**Stantec Architecture Inc.**  
722 12th Street NW Suite 100, Washington DC 20005-3957

**Reference:** New Mexico Proton Advanced Cancer Therapy (NMPACT)  
Response to Development Review Board Comments  
Project: PR-2022-007588  
Application: SI-2022-01658

LANDSCAPE - LANDSCAPE PLAN

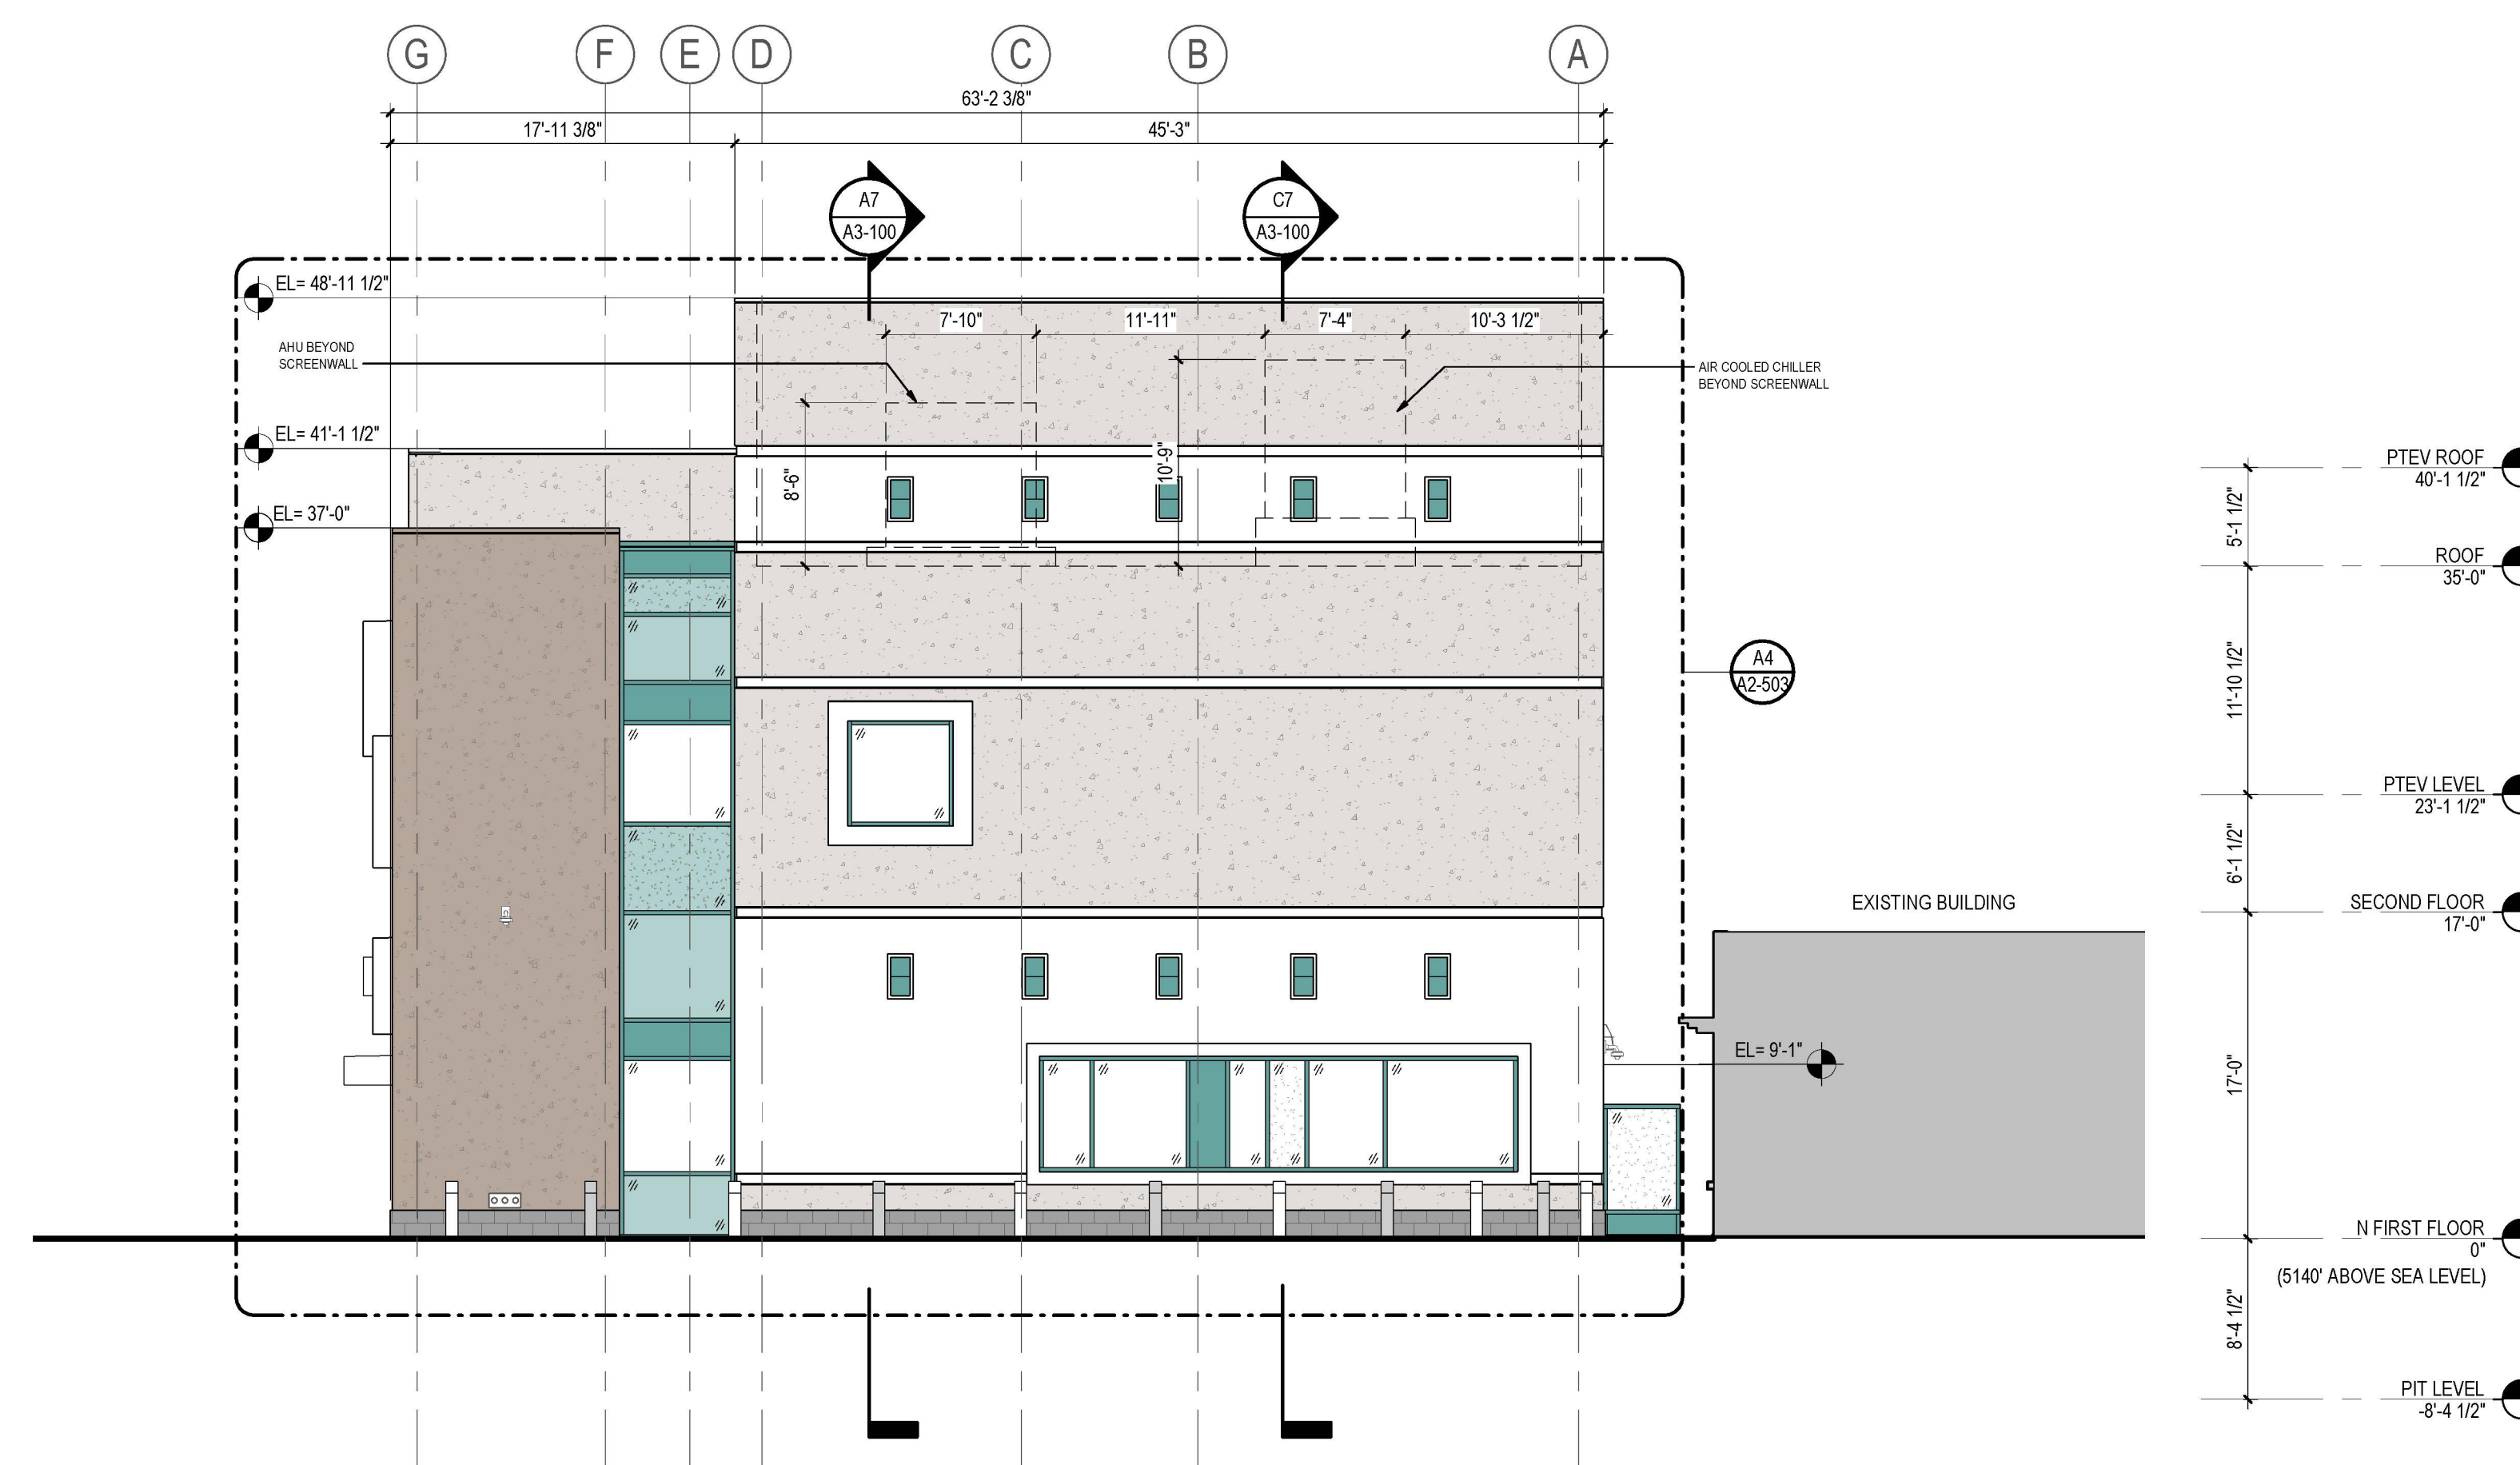
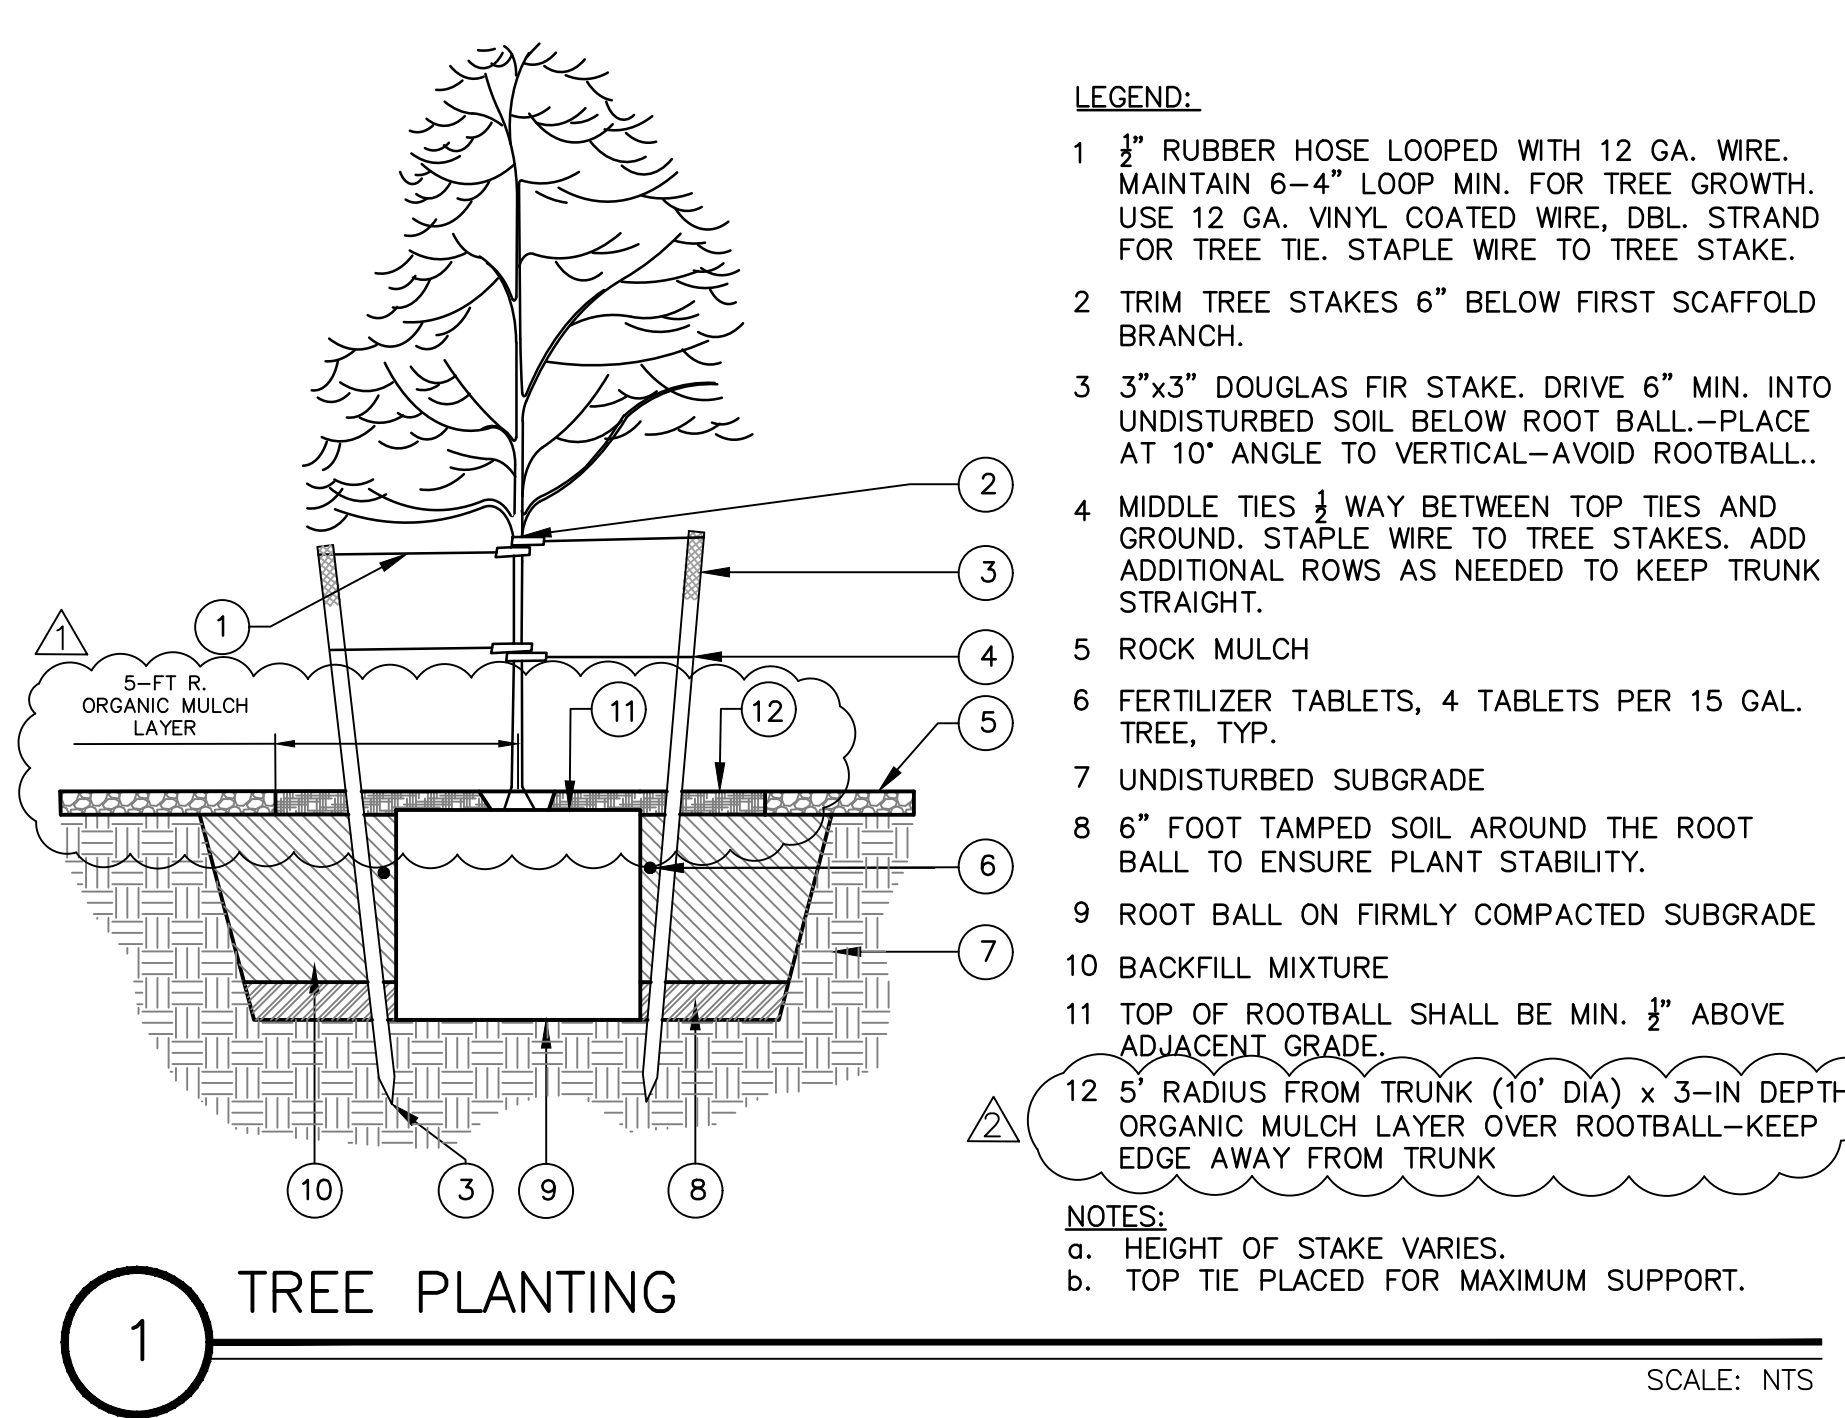
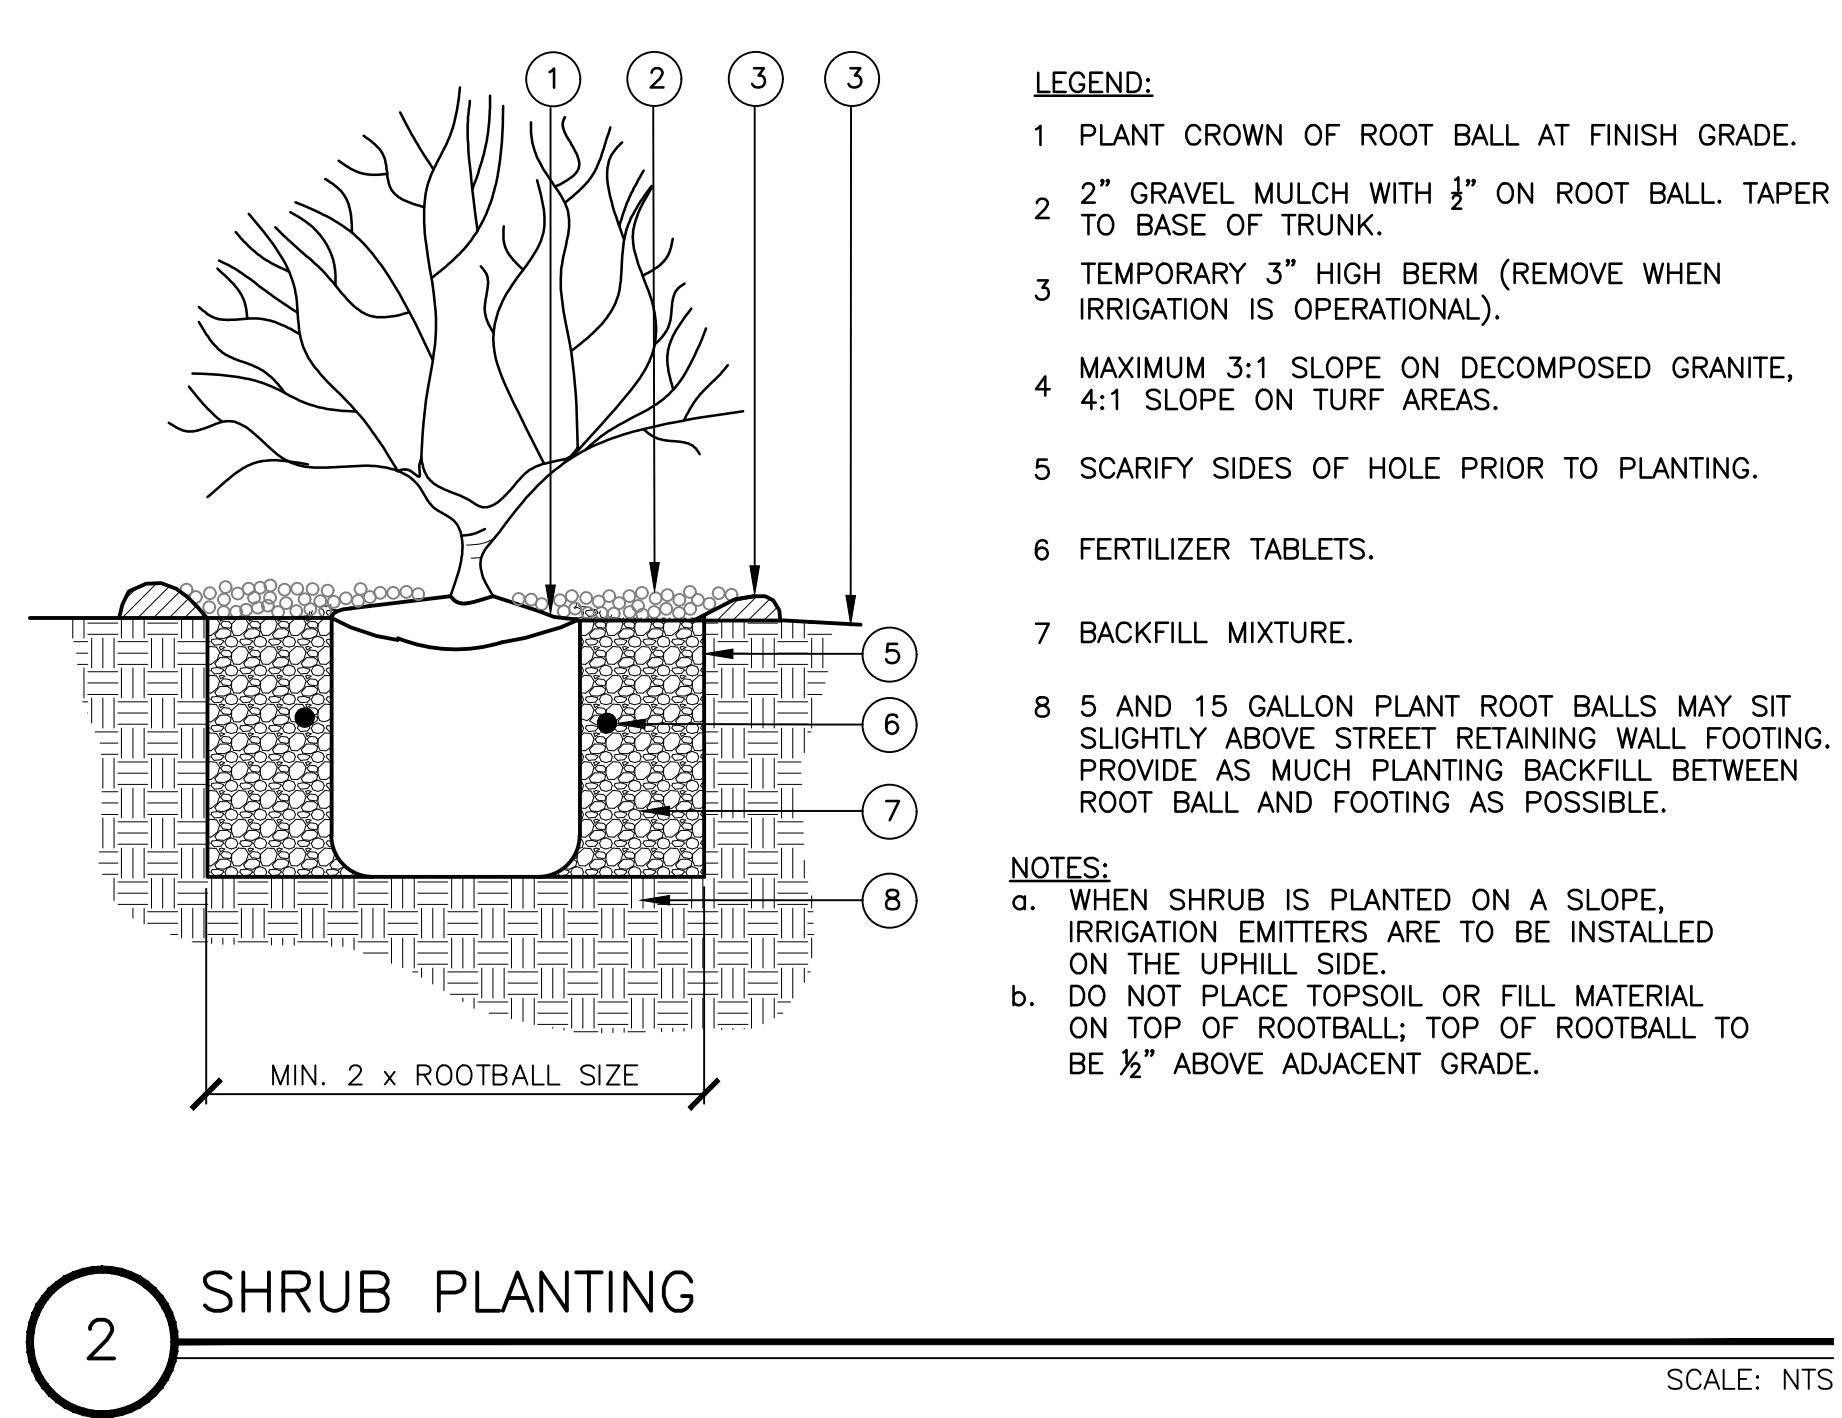
- a. *Stantec Response: Sheet C-101, Site Plan has been updated with the required information. See attached.*
10. The Landscape Plan must meet the 15% net lot area landscaping requirement per 5-6(C)(2) of the IDOS. Confirmation and calculations of this requirement must be provided on the Landscape Plan. (The plan sheet seems to state that the fire lane makes this requirement non-applicable, however staff is not able to confirm this per the IDO.)

11. The Landscape Plan depicts the removal of two large Chinese Pistache trees from the parking area. Staff discourages the removal of mature trees from a development if there is a way to save them. Please explain and justify their removal.
  - a. *Stantec Response: The existing, mature Pistache trees are removed because they will be negatively impacted by construction of new fire lane improvements. In our experience they would not survive trenching and installation of new curbing because its within their critical root zone (5-10 feet of their trunks). Additionally, construction of the new parking lot will recompact the soil - creating oxygen deprivation. We propose new trees in new planter conditions as the surest approach to providing healthy plants.*

- a. *Stantec Response: Noted. Background information provided in the attached NMCC Parking Study.*
5. Landscaping must meet requirements of IDO 5-6, Landscaping, Buffering, and Screening. Provide revised calculations showing how it is meeting IDO requirements.

1. Please add note to tree planting detail pursuant to IDO 5-6(C)(5)(e): "Organic mulch is required as ground cover under trees within a 5-foot radius around the tree trunk, but not directly against the trunk. In these areas, weed barrier fabric is prohibited."
  - a. Stantec Response: Sheet C-701, Landscape – Landscape Plan has been updated to include the note; reference Detail 1. See attached.

- a. *Stantec Response: Net lot area landscaping has been calculated for the entire site and the project exceeds the 15% minimum requirement. Sheet C-701, Landscape – Landscape Plan has been updated with the calculation. See attached.*

- a. *Stantec Response: Required calculations for IDO 5-6 have been added to tables on C-701 (attached). The project is in compliance with following exceptions:*

- i. 5-6(D)(2) – Additional Street Frontage – landscaping around building foundation. This is not met, and a variance is requested due to site constraints and potential impact to lost parking.
  - ii. 5-6(E) – Edge Buffer Landscaping. This is not met along the southern and eastern sides of the property. The existing trees are spaced at wider intervals and a variance is requested due to budget.
  - iii. 5-6(F) Parking Lot Landscaping. This is met for new improvements but is not met for existing. Existing lots have it about 200' (versus 100' requirement). A variance is requested due to budget.
6. Signs must meet requirements of Master Plan and, were silent, IDO 5-12, Signs.
    - a. Stantec Response: Noted.
  7. Code Enforcement has no further comments at this time.
